Appeal Decision

Appeal Ref: APP/R5510/D/21/3270511

41 Acacia Avenue, Hayes, UB3 2ND

- The appeal is made under section 78 of the Town and Country Planning Act 1990 against a refusal to grant planning permission.
 - The appeal is made by Mr Aftab Adamjee against the decision of the Council of the London Borough of Hillingdon.
 - The application Ref 16106/APP/2020/3451, dated 23 October 2020, was refused by notice dated 24 December 2020.
 - The development proposed is described as '*Add a rear dormer to the existing loft conversion and two roof windows to front slope roof*'.
-

PROPOSED ROOF PLAN

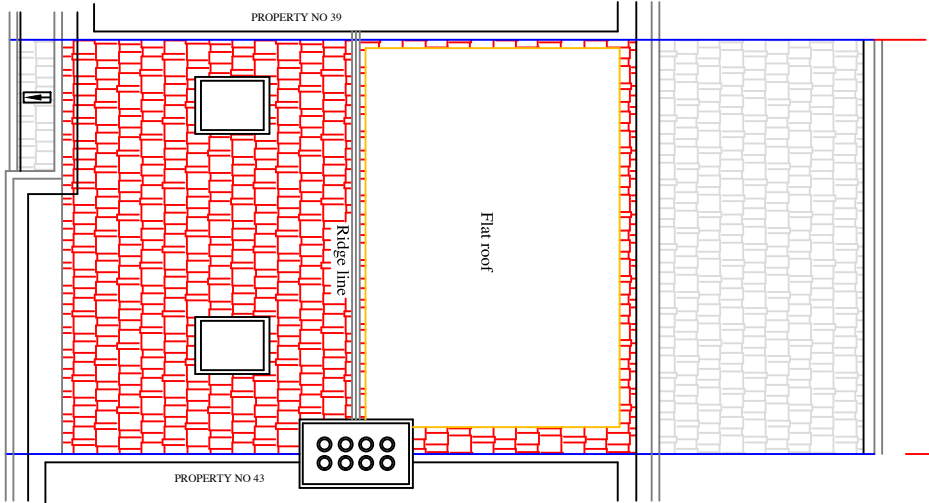
6. In this instance the dormer would be only very marginally set below the roof's ridge and up from the eaves. It would also be just marginally stepped in from both side boundaries, spanning significantly more than two thirds of the roof. There would be little of the rear roof slope visible to frame the dormer extension such that it would effectively appear as a bulky, additional storey to the dwelling. This would be openly seen in views from the public domain to the rear looking into the CA where the roof form to this part of the terrace would be completely altered beyond its original shape and character. To my mind the dormer would precisely represent the scale and form of roof extension that Policy DMHD 1 seeks to prevent.

PROPOSED REAR ELEVATION

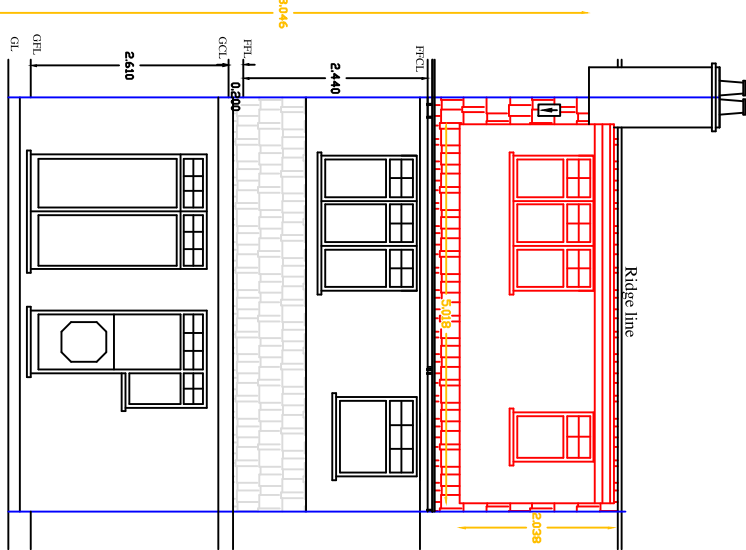
7. Overall, due to its size and bulk, I find that the dormer window would appear as a discordant and harmful addition that would detract from the simple form and character of No 41 and the wider terrace as a whole. Its unsympathetic appearance would fail to display the quality of design that is required by both Policy BE1 of the Hillingdon Local Plan Part 1 (HLP Part 1) and Policy DMHB 11 of the HLP Part 2, and the Framework's objectives for achieving well-designed places. Based on this level of visual harm, it follows that the proposal would neither preserve nor enhance the character or appearance of the CA, regardless of the nature or quality of development nearby, or the fact that the dormer would face towards land and property that is outside of the CA boundary. In this regard there would be conflict with HLP Part 1 Policy HE1, HLP Part 2 Policy DMHB 4 and Policy HC1 of the LP 2021, which has been drawn to my attention by the Council since the date of the original decision. Although the harm to the CA as a heritage asset would be less than substantial, there would be no public benefits arising from the proposal to weigh against the harm. As such, there would also be conflict with HLP Part 2 Policy DMHB 1 and the Framework's objectives for conserving and enhancing the historic environment.
